## **GREEN HILL SOLAR FARM – LAVENDON PARISH COUNCIL REPRESENTATION - NOVEMBER 2025**

### **THE COUNCIL’S CURRENT POSITION**

Title:
Figure 8.1.5 Site Locations and Study Area
Green Hill G

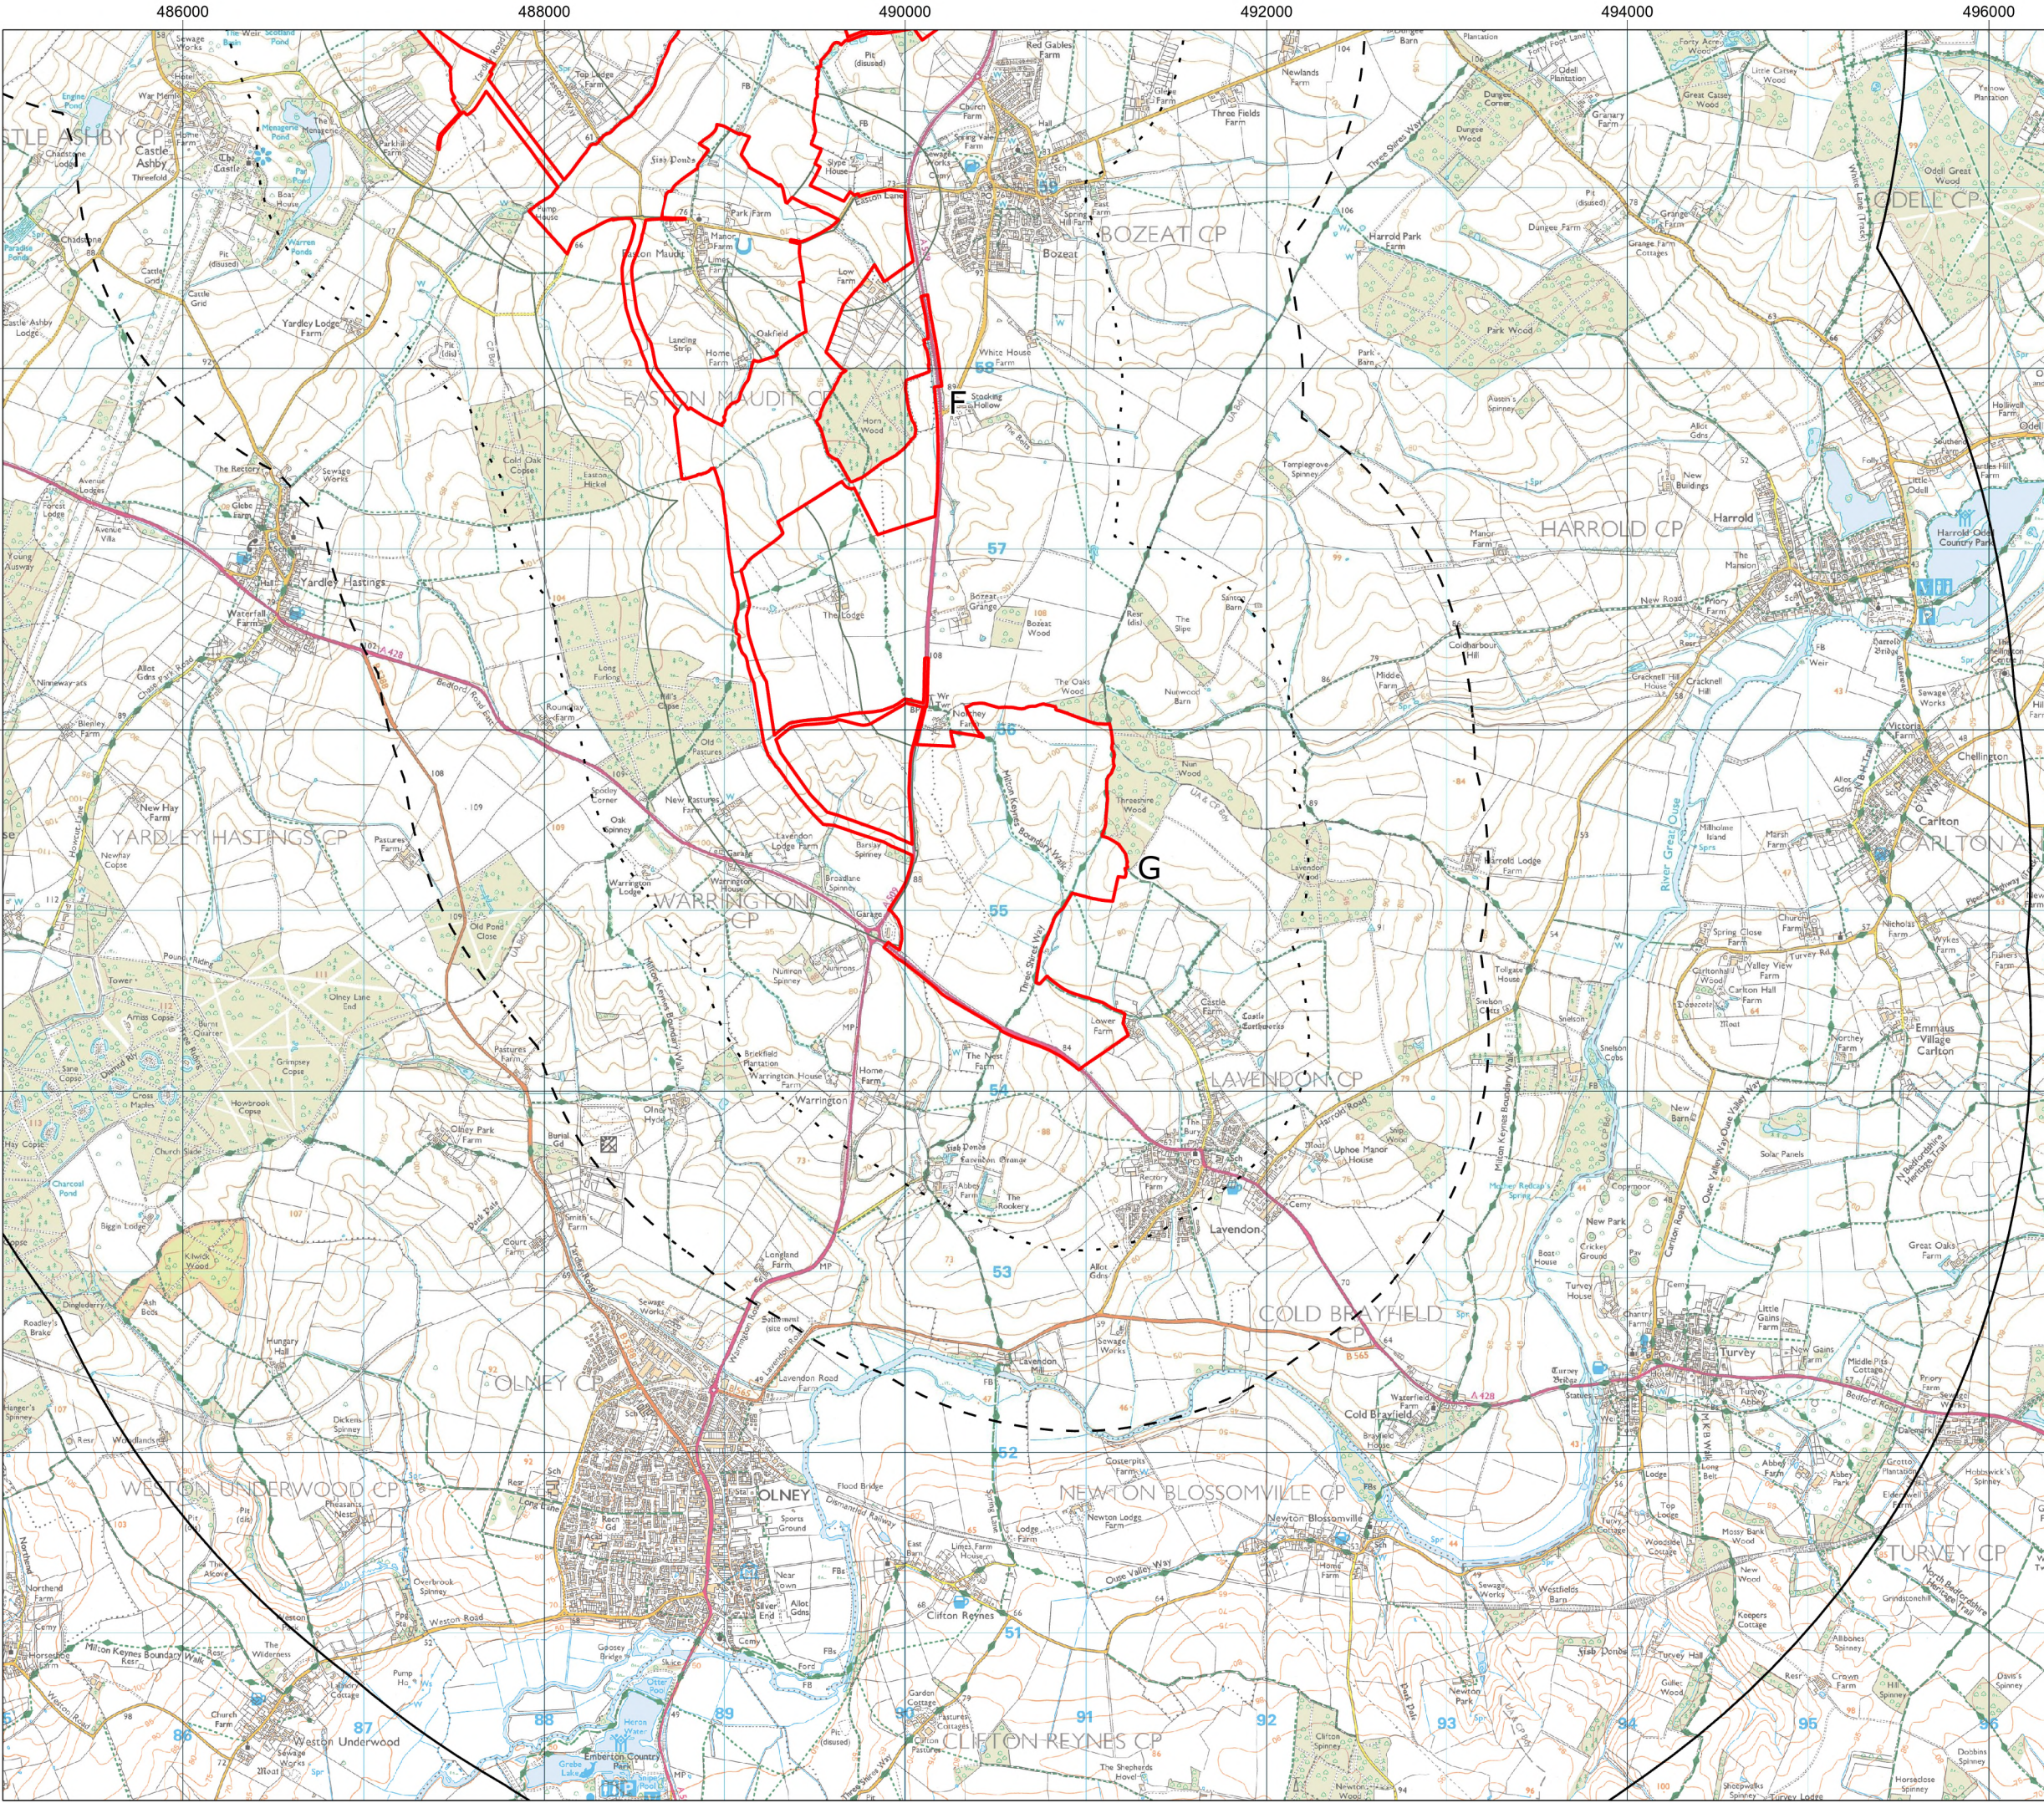
Field GF9 lies immediately adjacent to designated ancient woodland (Three Shires Wood). The proposed access track providing entry to this parcel would run within approximately 10 metres of the woodland edge. Given the typical methods employed in the construction of haul roads within solar farm developments, the potential for adverse effects on adjoining woodland habitats such as soil compaction, disturbance to root systems, and alteration of hydrological conditions would be difficult to avoid. The Council therefore considers that the risk to the ecological integrity of Three Shires Wood remains significant and insufficiently mitigated.

Field GF13 is situated closest to the settlement boundary and adjoins an ordinary watercourse along its northern edge. Lavendon has a well-documented history of flood incidents, and the local community has expressed legitimate concerns that the proposed development could exacerbate existing flood risk. This risk arises from the introduction of impervious surfaces associated with the photovoltaic (PV) arrays and ancillary infrastructure in close proximity to both the watercourse and residential properties. The Flood Risk Assessment and Drainage Strategy submitted by the Developer does not include a Sustainable Drainage System (SuDS) strategy, relying instead on the assumption that the reversion of arable land to grassland will improve infiltration rates and offset the increased runoff generated by the development. The Council does not consider this approach sufficiently robust to address localised flood concerns.

- Removal of PV arrays from field GF13, to allow this parcel to be repurposed for the delivery of multifunctional flood attenuation and ecological mitigation measures. Specifically, The Council recommends that this area be instead utilised for biodiversity enhancement, for example through the creation of skylark plots and other open-habitat features to offset the loss of foraging habitat arising from the installation of PV infrastructure elsewhere within the site.

- Removal of field GF9 from the scheme, to be similarly repurposed for ecological mitigation and enhancement. This would help maintain habitat connectivity with the adjacent ancient woodland (Three Shires Wood) and contribute to the overall biodiversity net gain and landscape mitigation objectives of the scheme.
